From: Tom Errico <thomas.errico@tylin.com>
To: Jean Fraser <JF@portlandmaine.gov>
CC: David Margolis-Pineo <DMP@portlandmaine.gov>, Katherine Earley <KAS@port...>
Date: 7/2/2015 2:46 PM
Subject: 81 Industrial Way - Updated Traffic Comments

Jean - The following is a status update on my June 16th comments.

SITE PLAN
OF:
LOT 5 INDUSTRIAL WAY
91 INDUSTRIAL WAY
PORTLAND, ME 04103

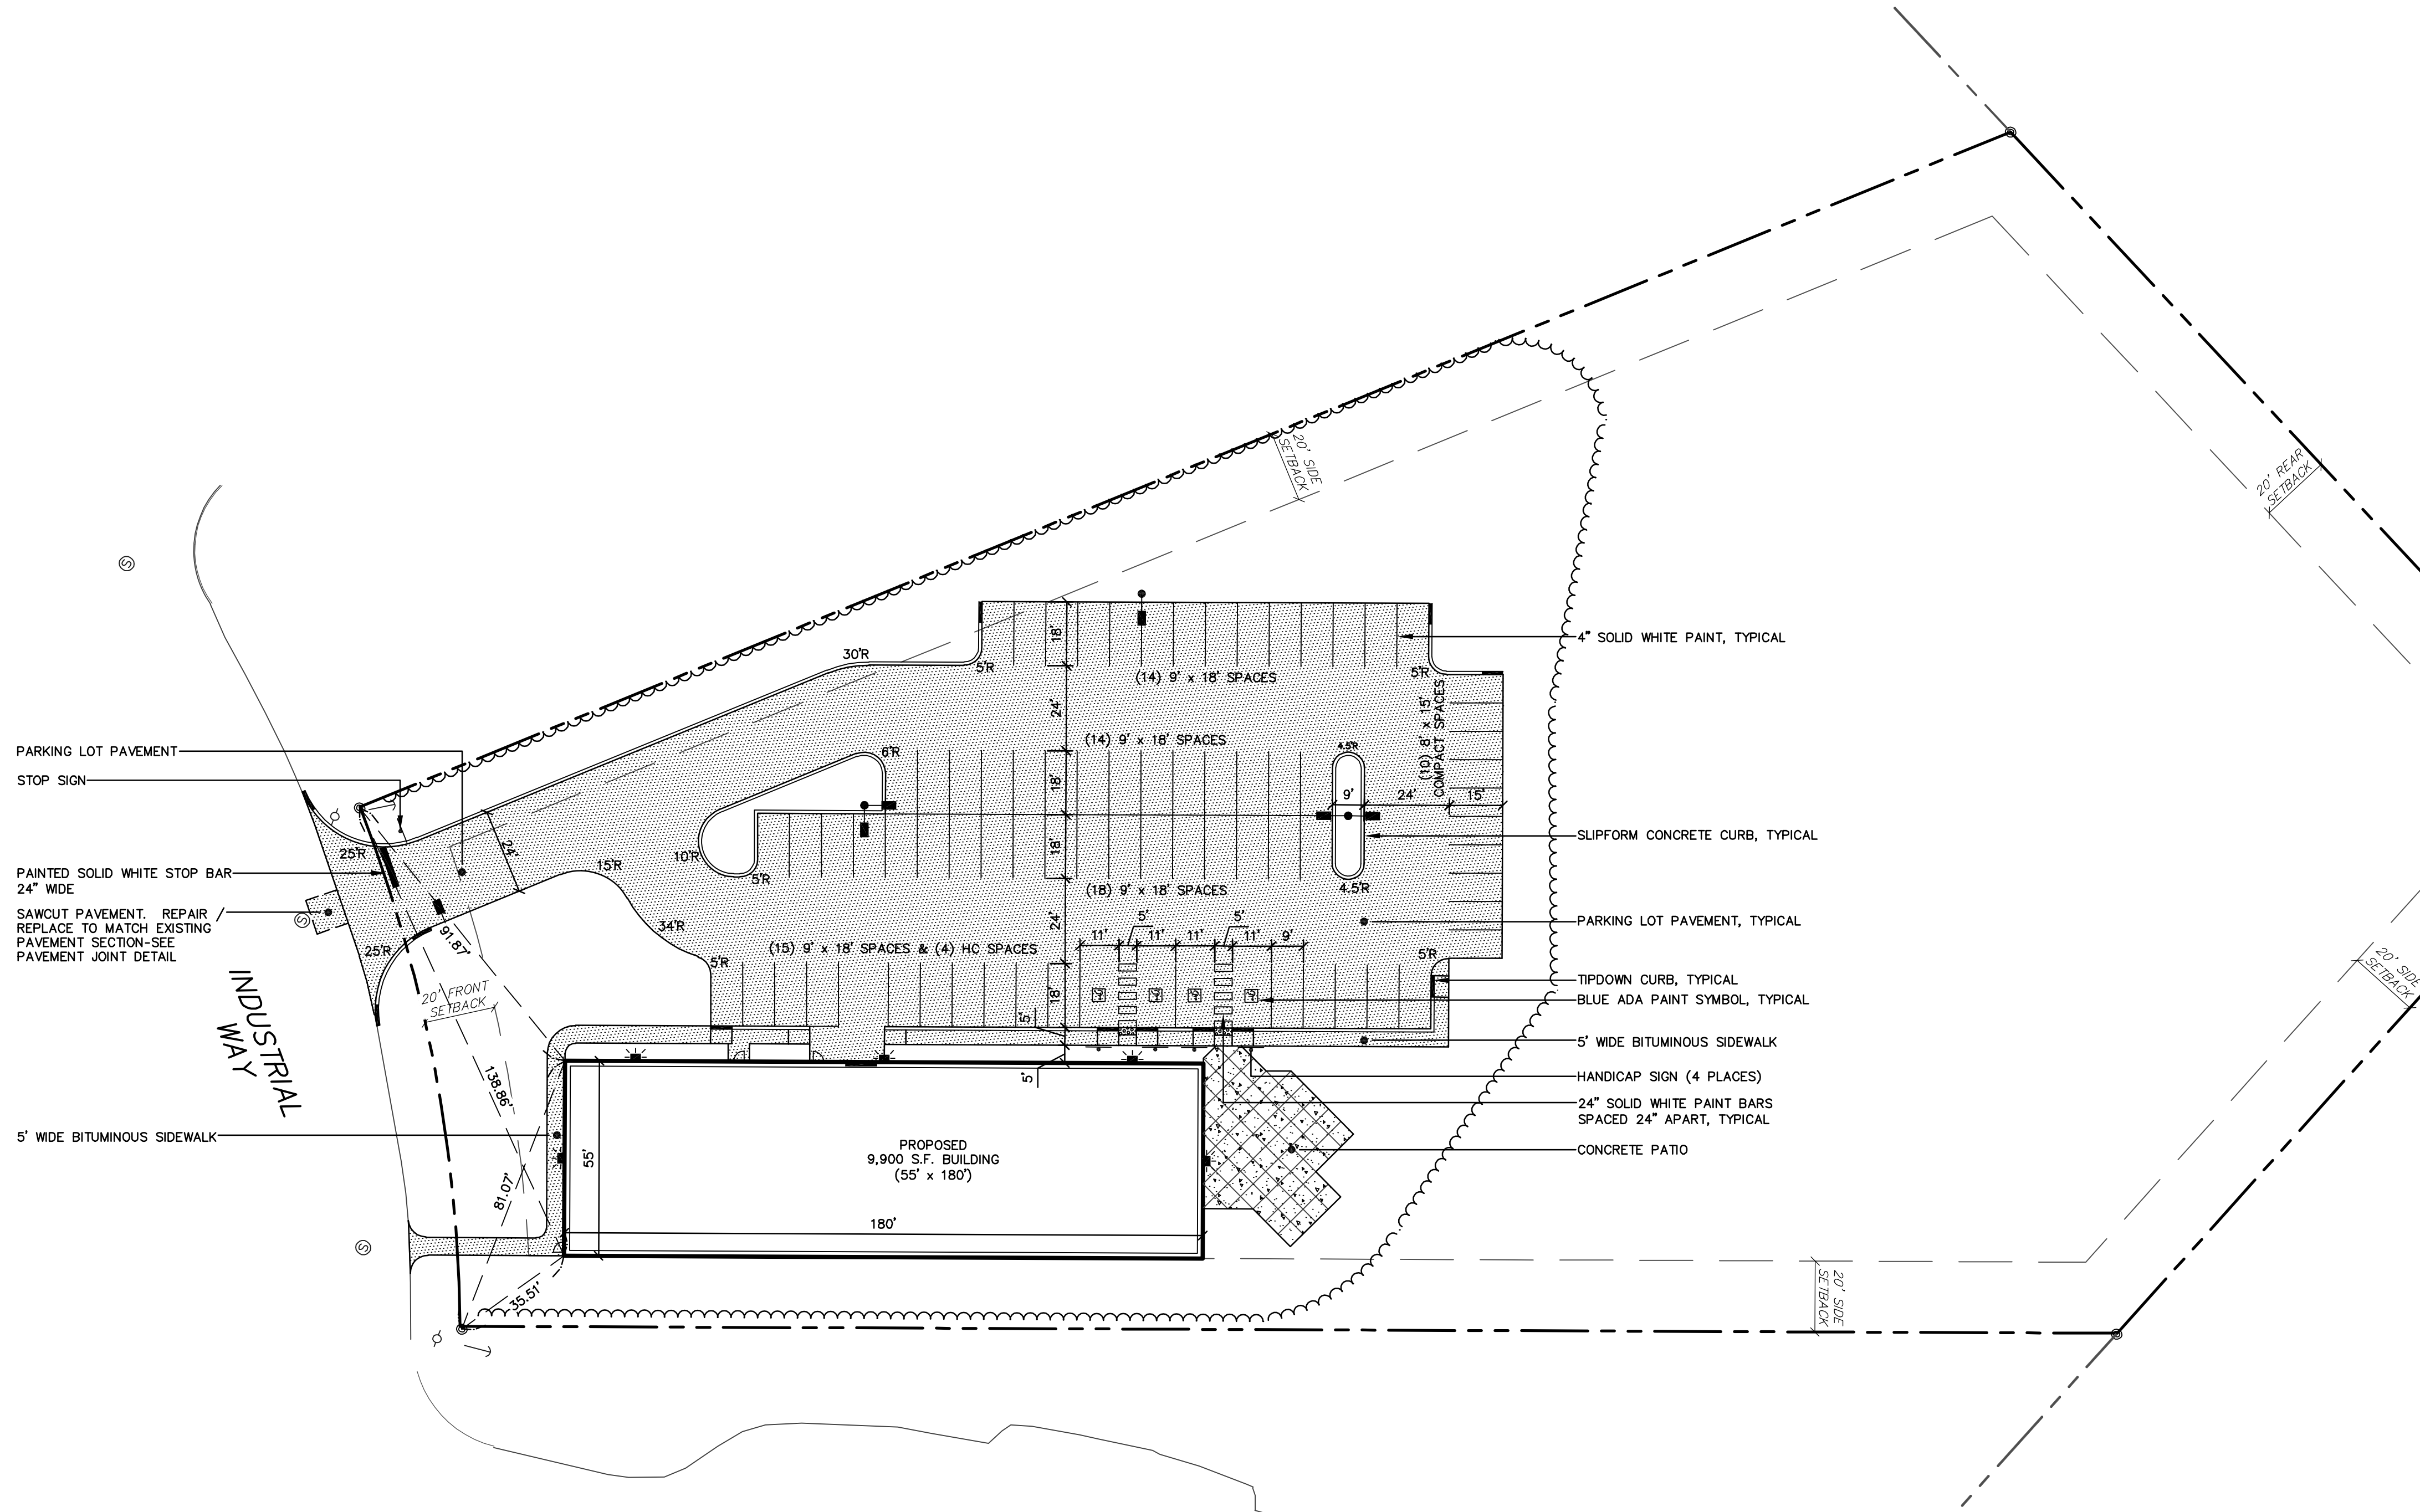
* I would expect pedestrian activity between the existing site and the proposed office building and as such the applicant should provide details on routing and facilities to safely accommodate pedestrians.

Status: The applicant has provided a pedestrian connection from the proposed building to Industrial Way. The applicant should also note how pedestrians will safely walk from Industrial Way to the existing 50 Industrial Way buildings.
